NSW GOVERNMENT
Department of Planning

Major Project Request – Mixed use development (MP08_0244)

Lot A in DP 418891, Lot 11 in DP 713206, Lots 101, 102 and 103 in DP 1067930 and Lot 3 in DP 713505 – 23, 23A, 27 – 37 Lindfield Avenue and 11 Havilah Lane, Lindfield.

1 JUNE 21 -9AM
1:500

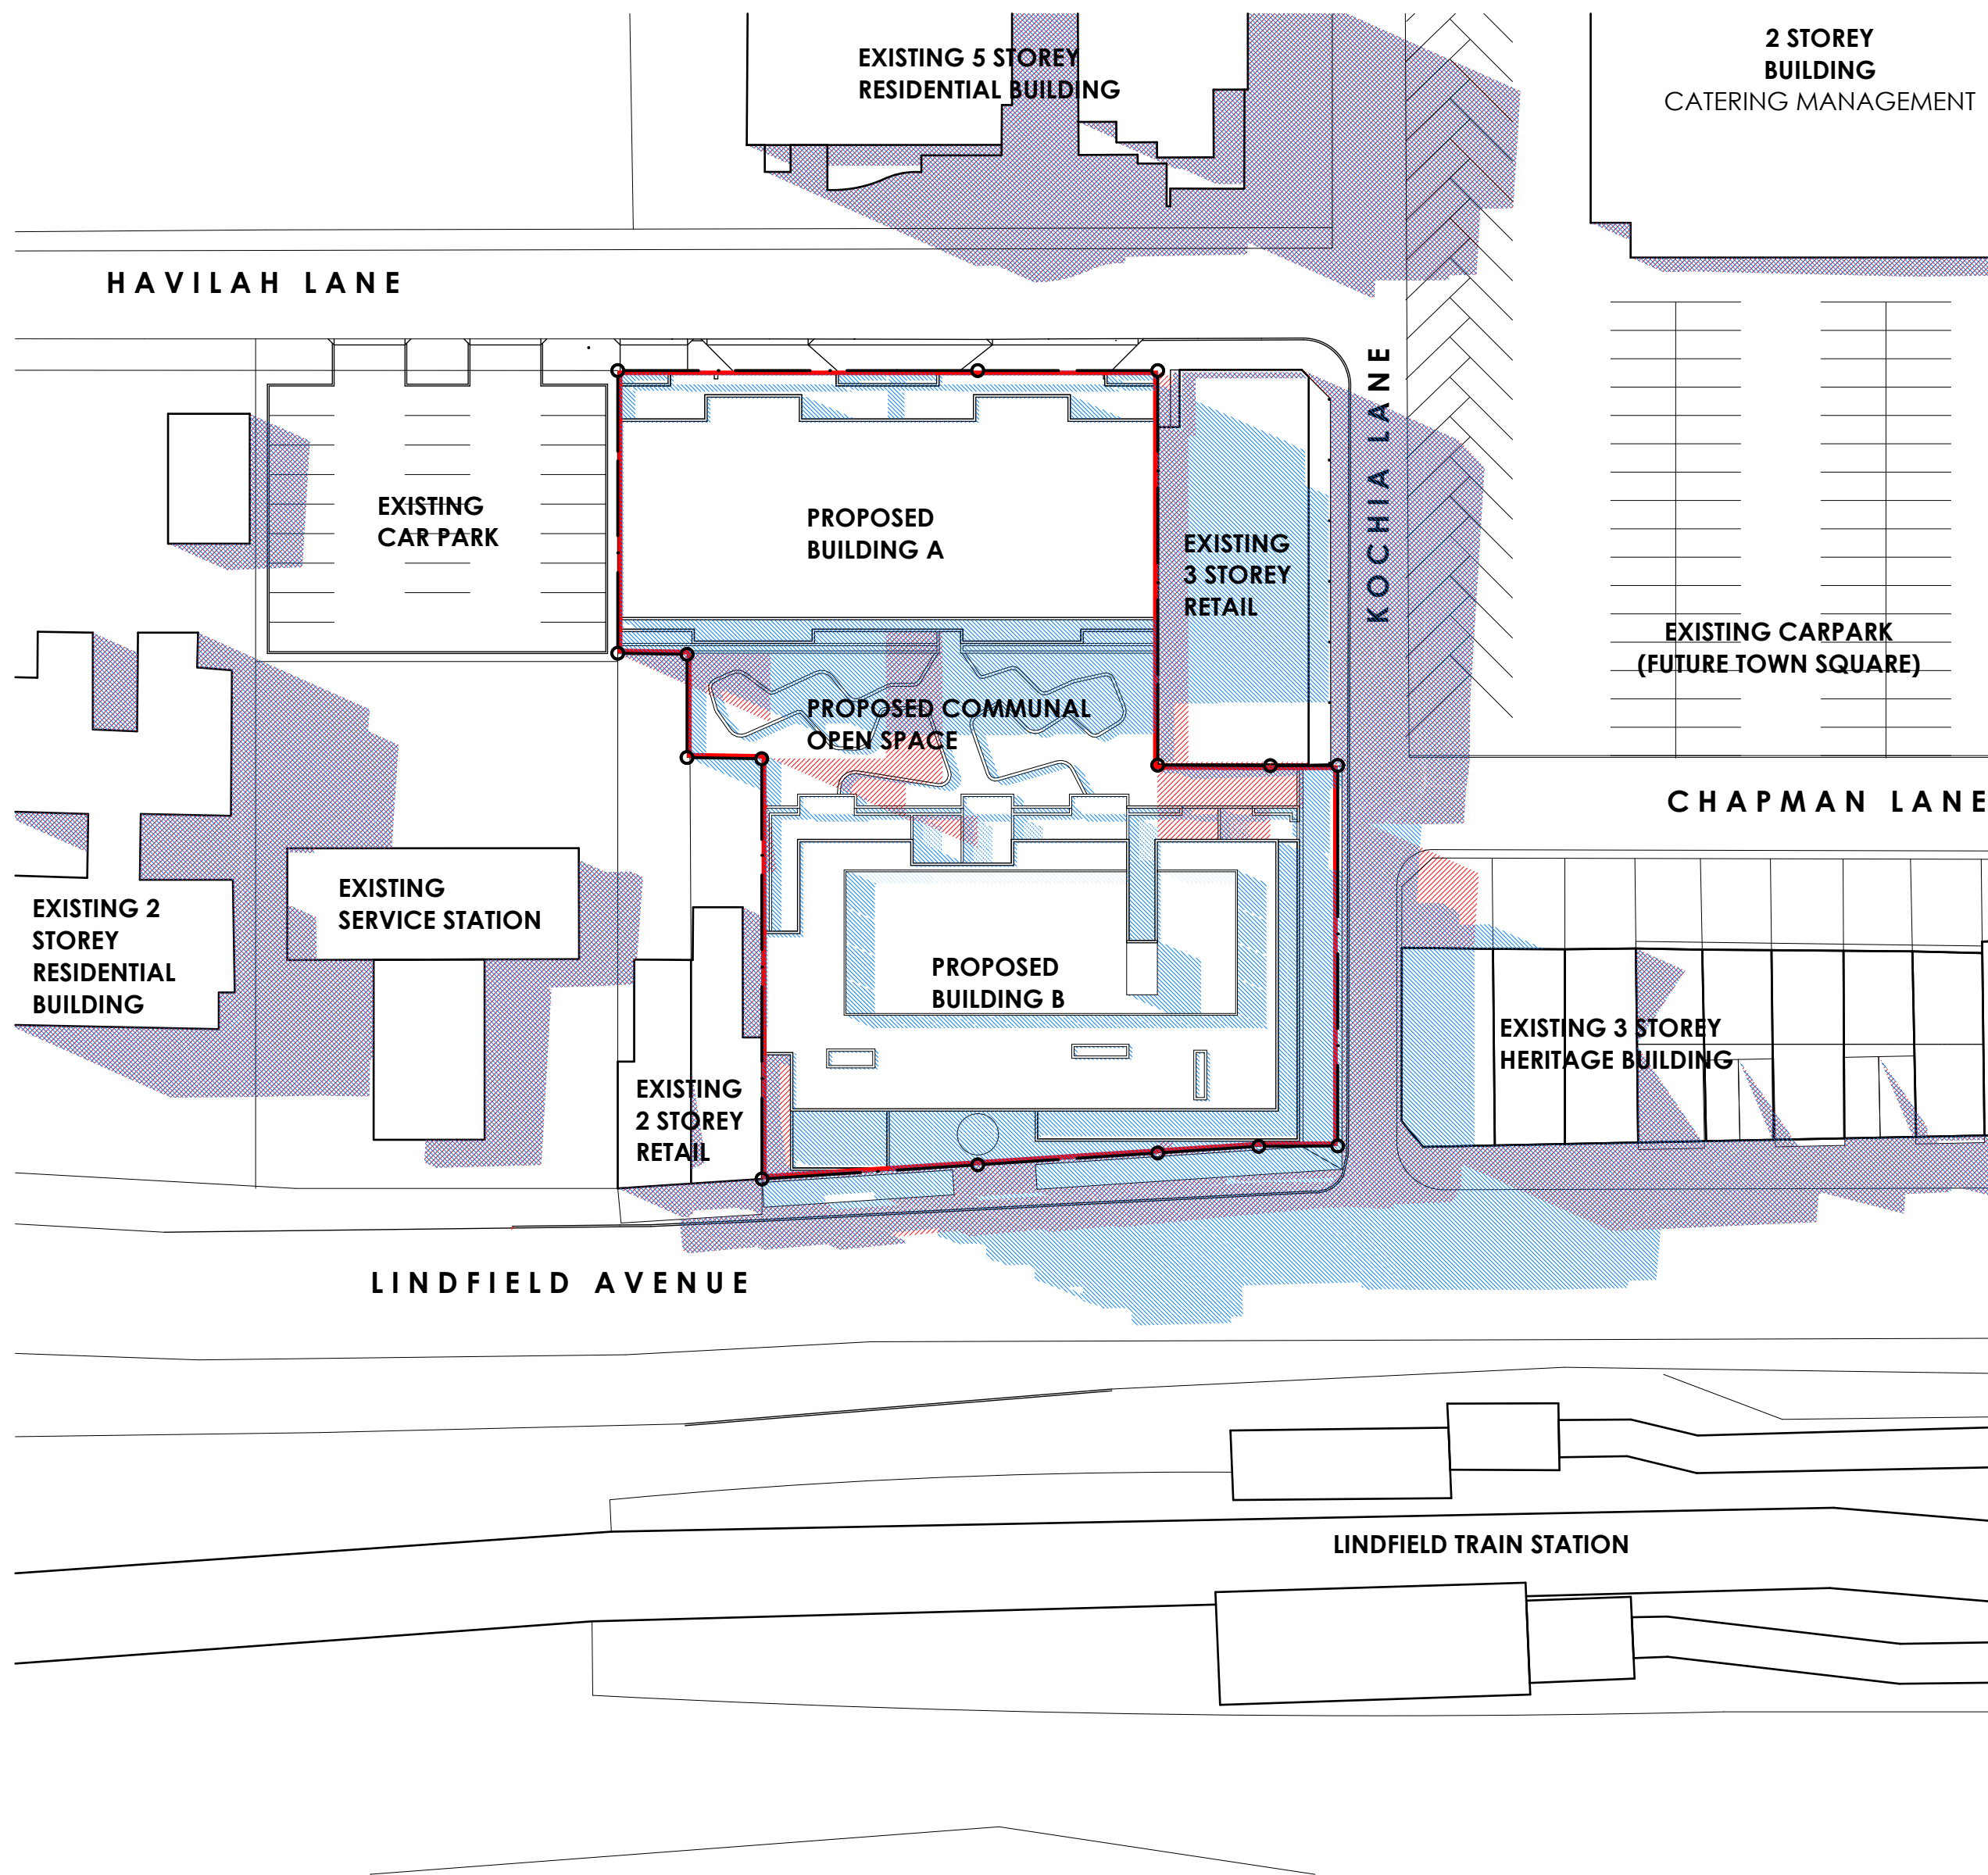
Careful consideration should also be given to the visual relationship between the existing residential development to the north-east (rear lane) and the heritage listed building to the south, along Lindfield Avenue. Particular care should also be given to the treatment of the loading dock area. The design of the private communal open space should ensure optimum levels of solar access are provided in accordance with the provisions of SEPP 65.

DRAWING TITLE:  
CONCEPTUAL FUTURE CORNER SITE DEVELOPMENT

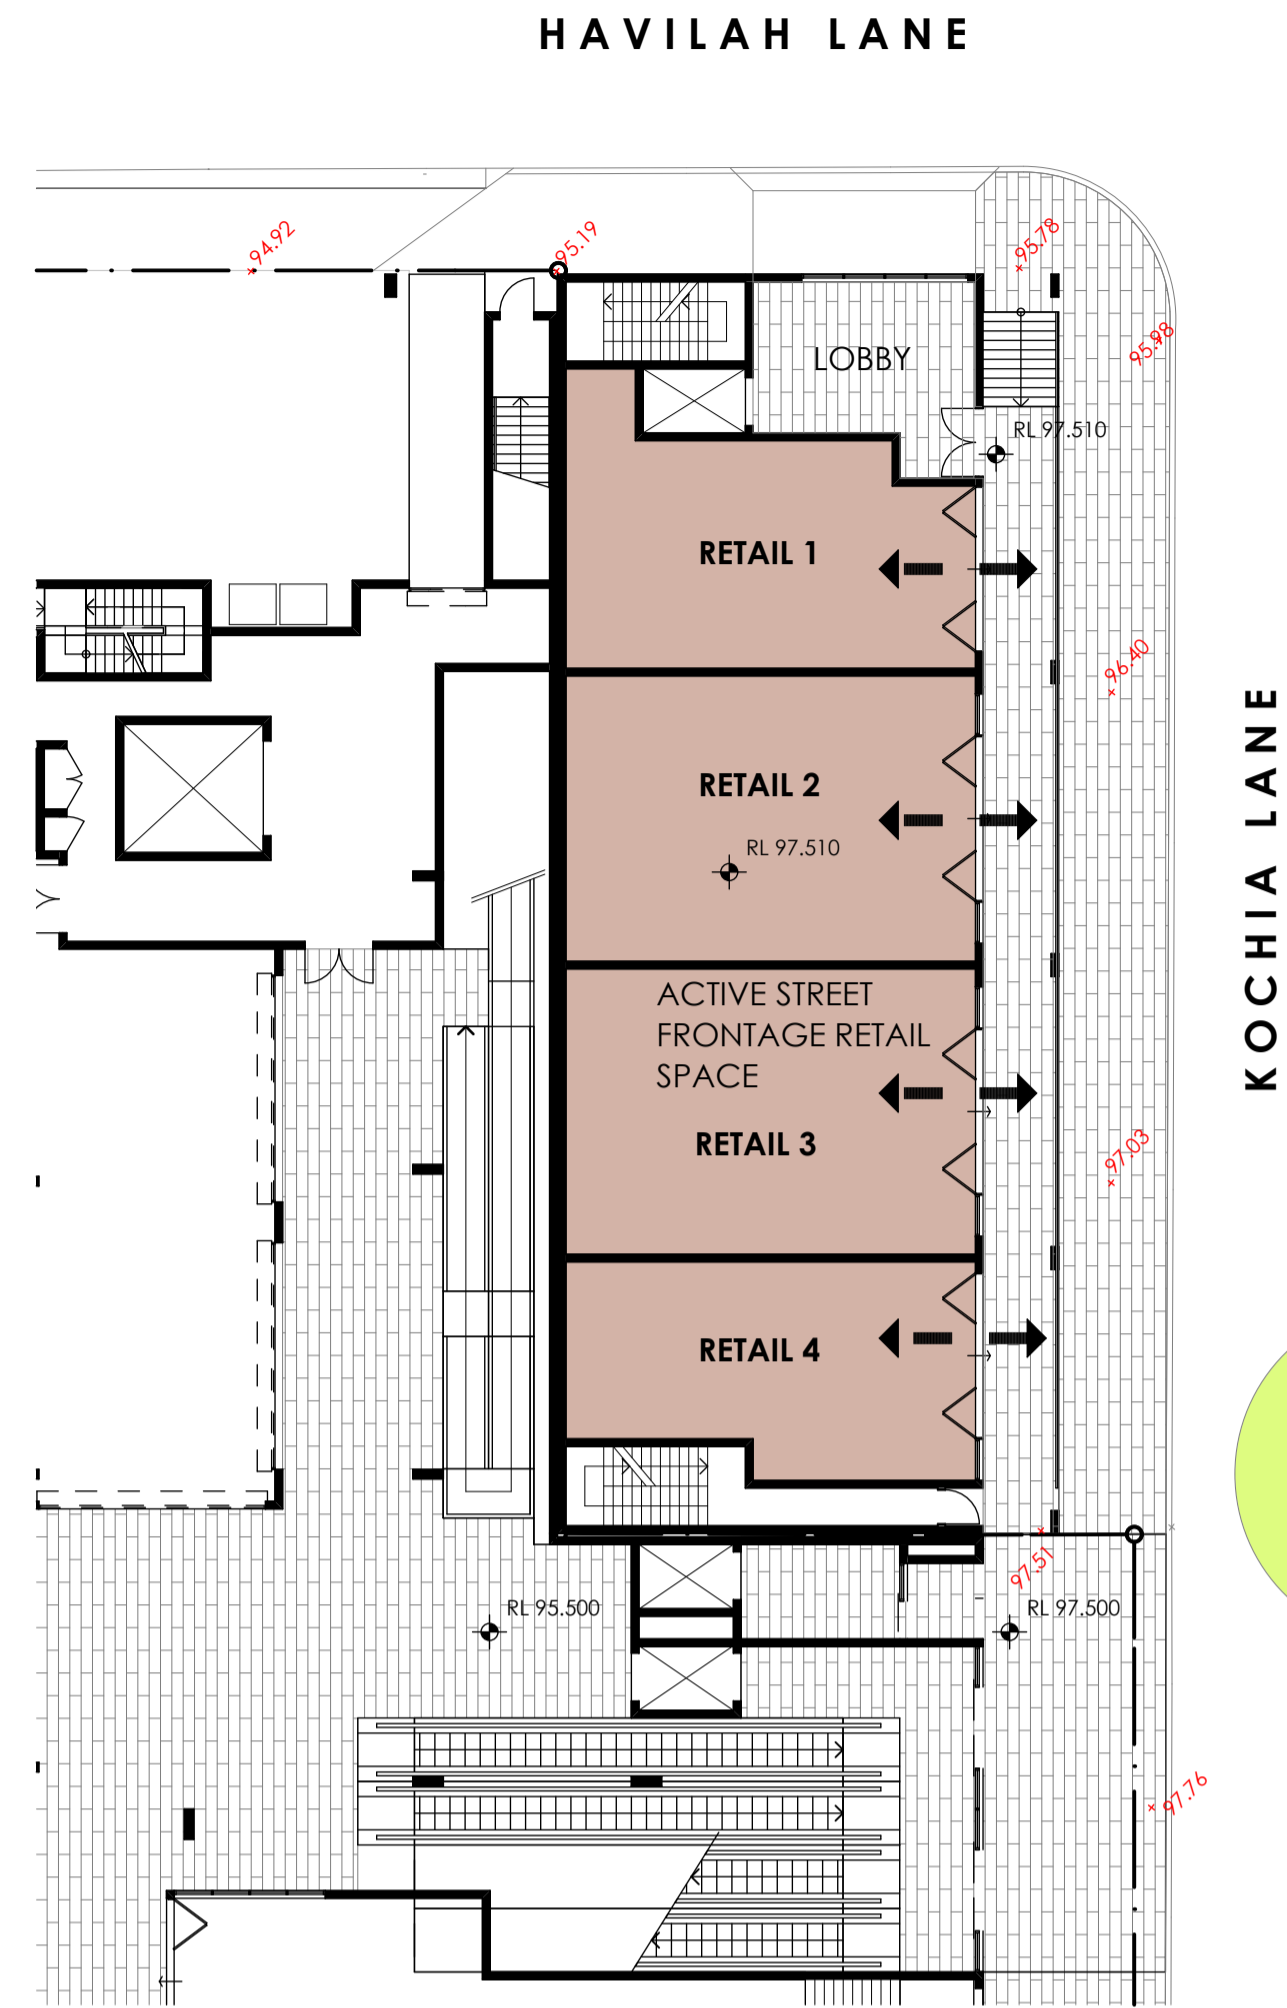
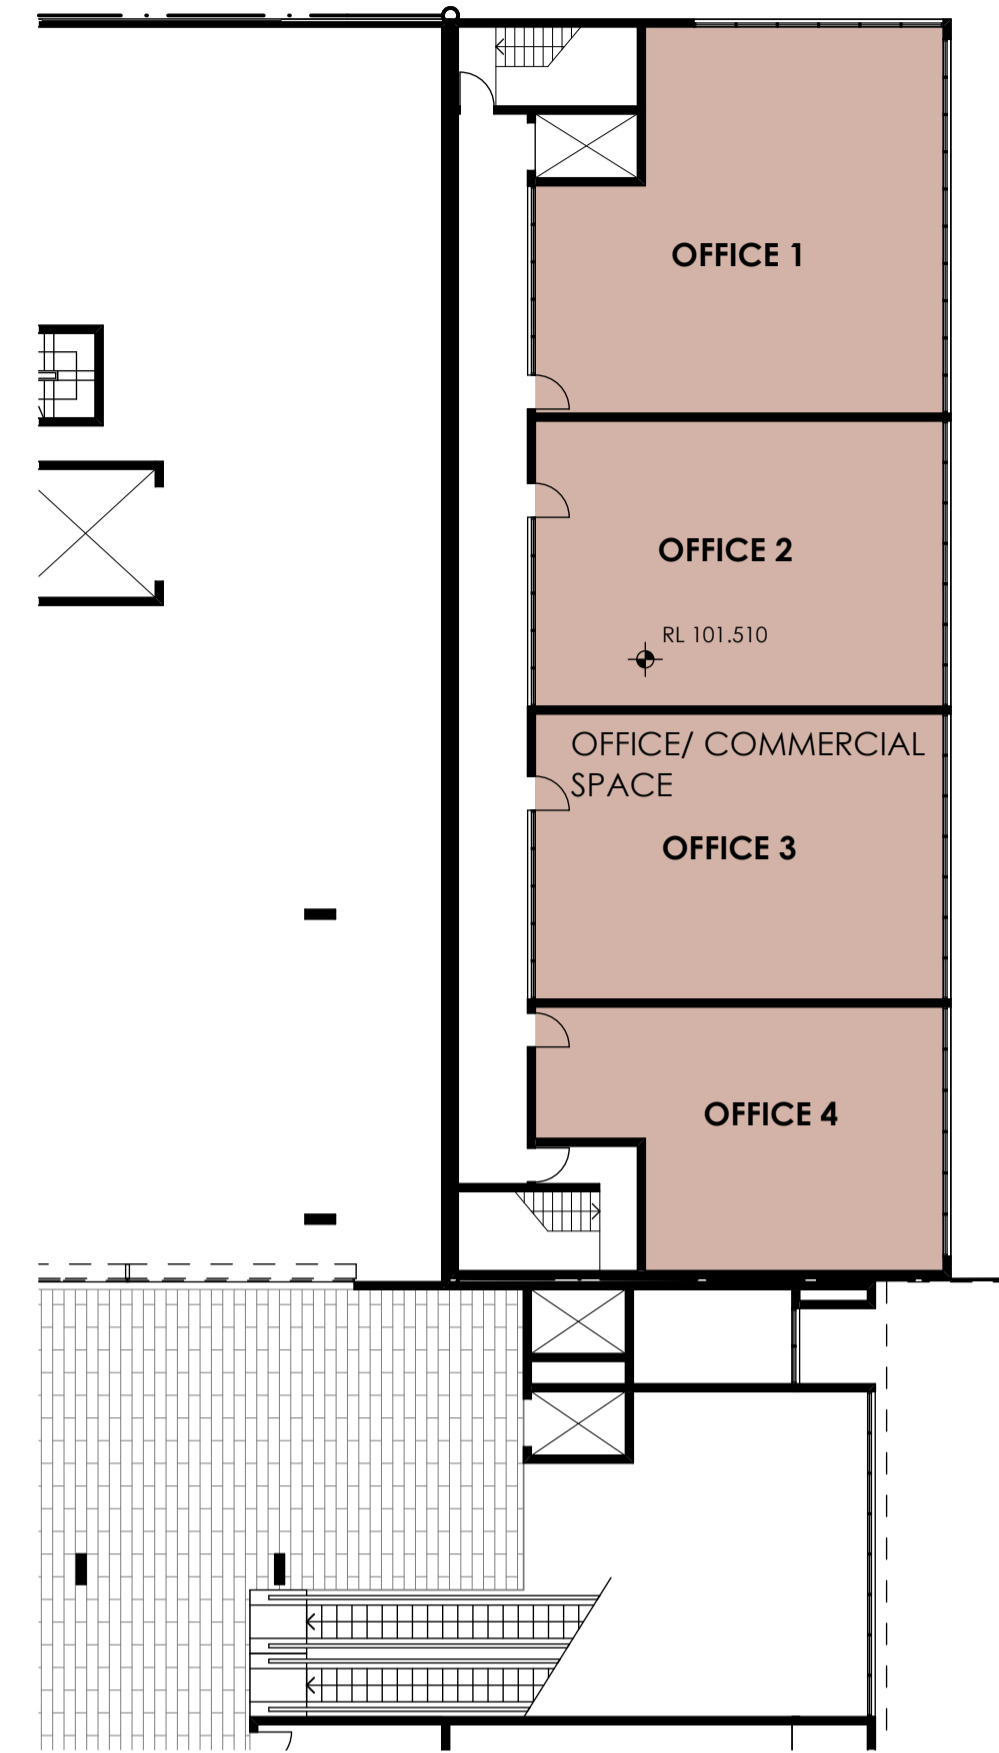
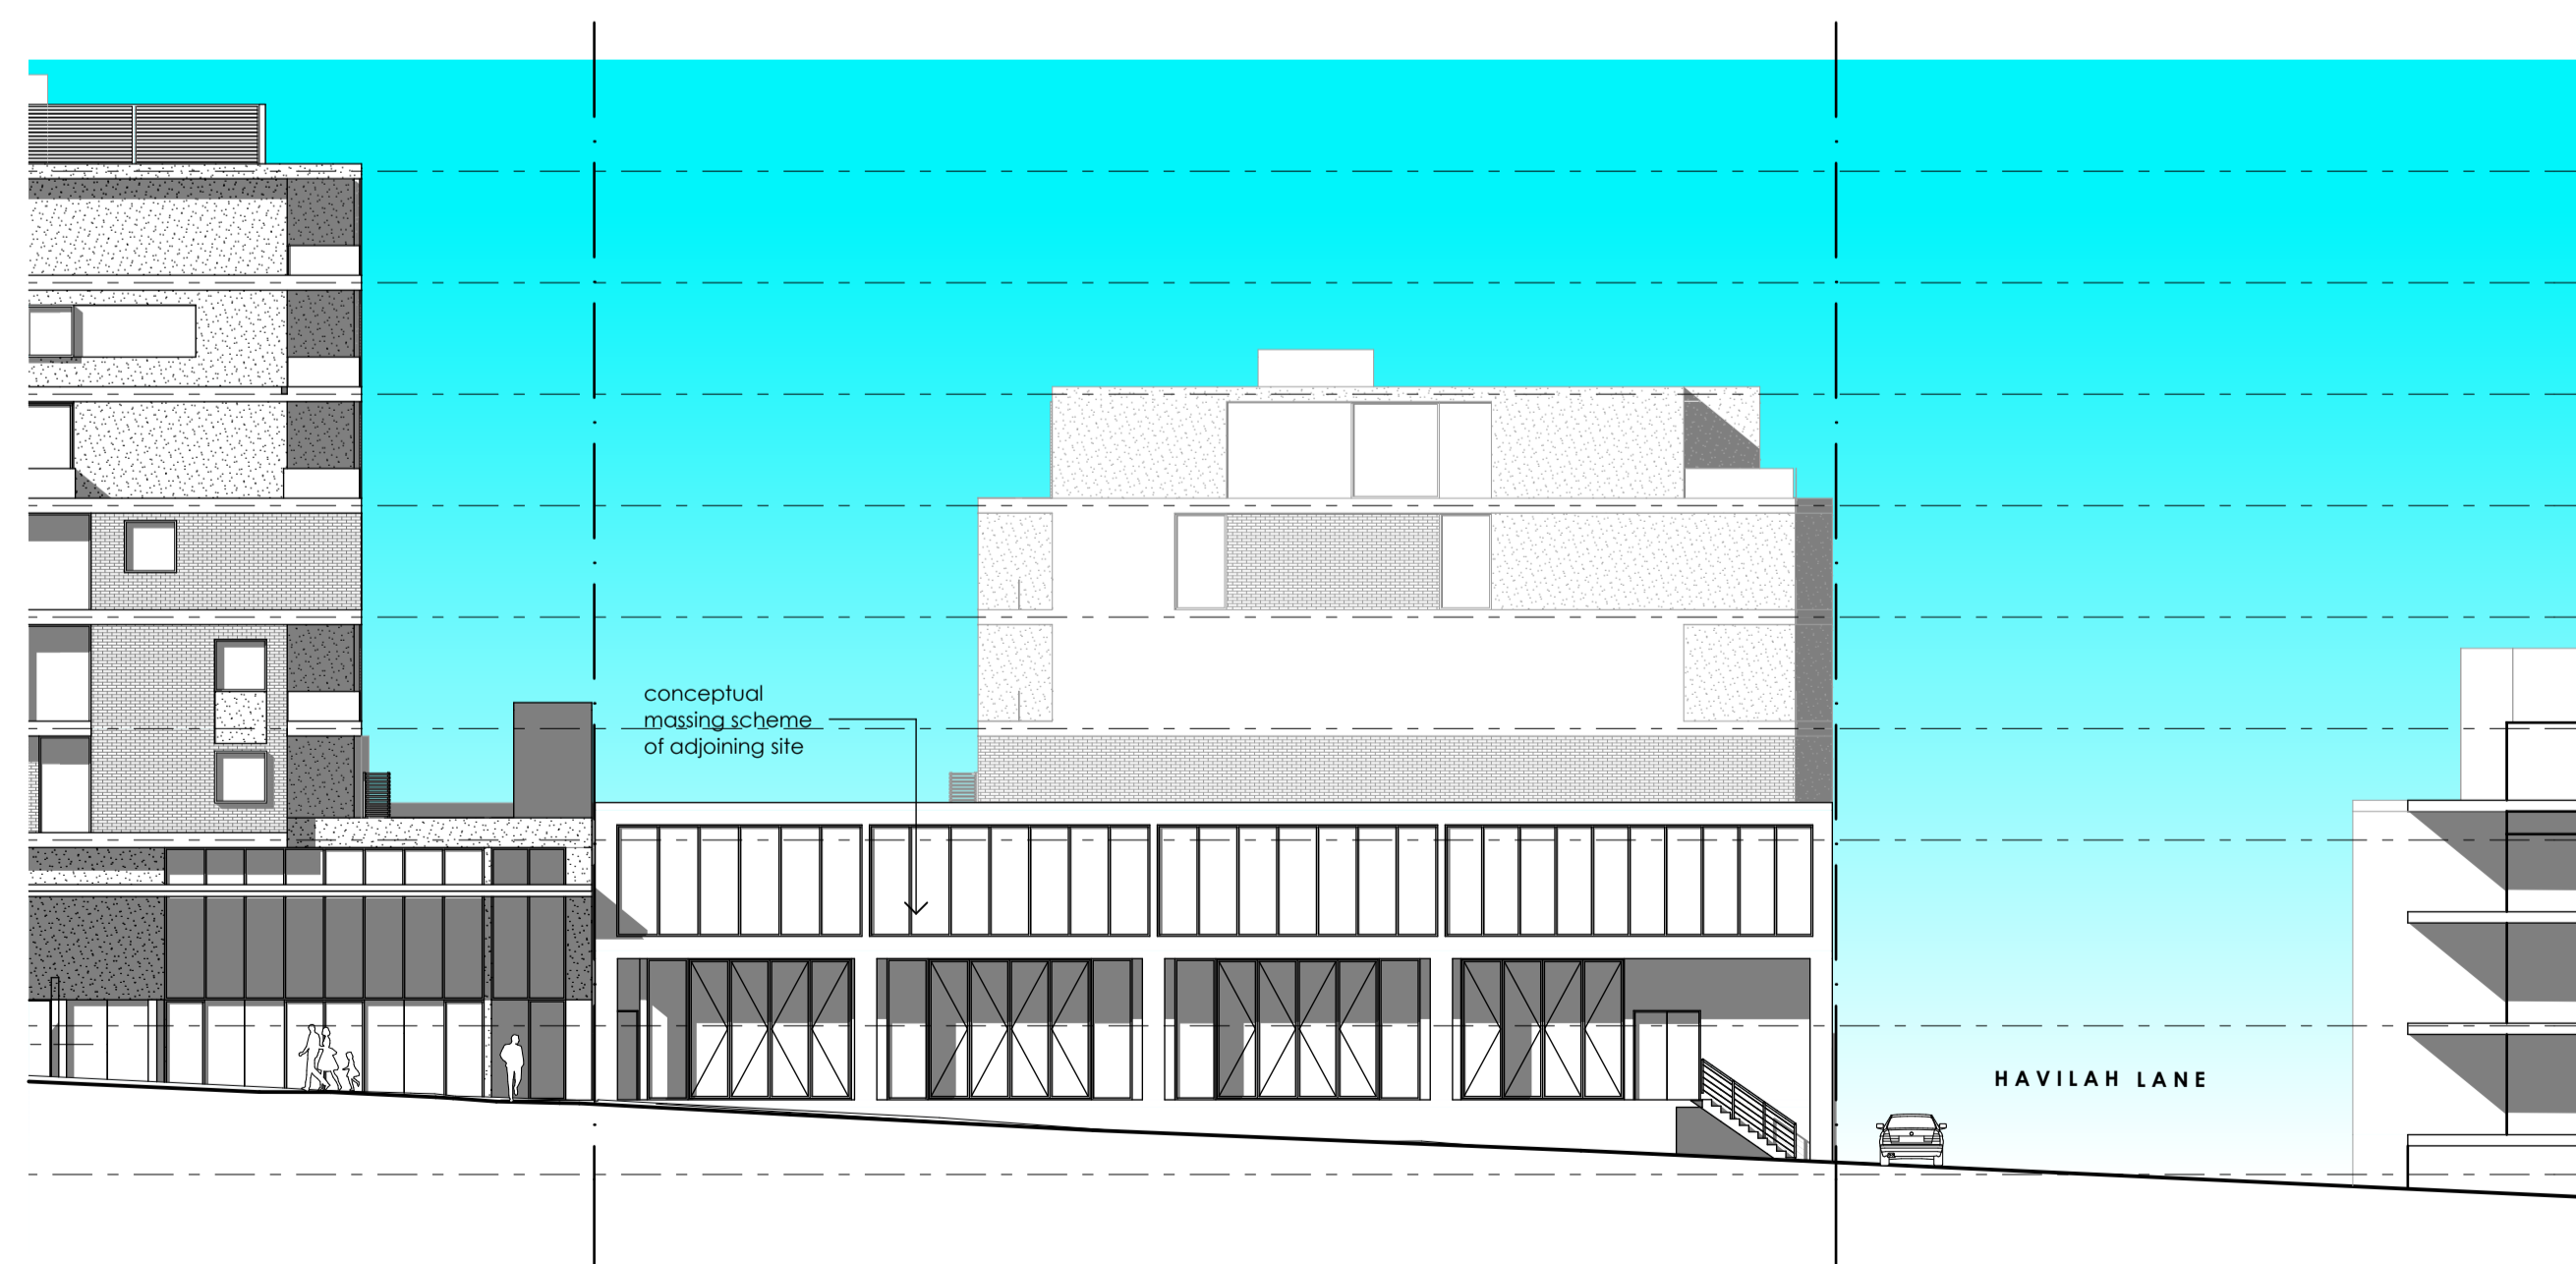
The Department has concern regarding isolation of 2 Kochia Lane in the eastern corner of Site 4. The design should ensure any future development on the site is not compromised by the exclusion of this site.
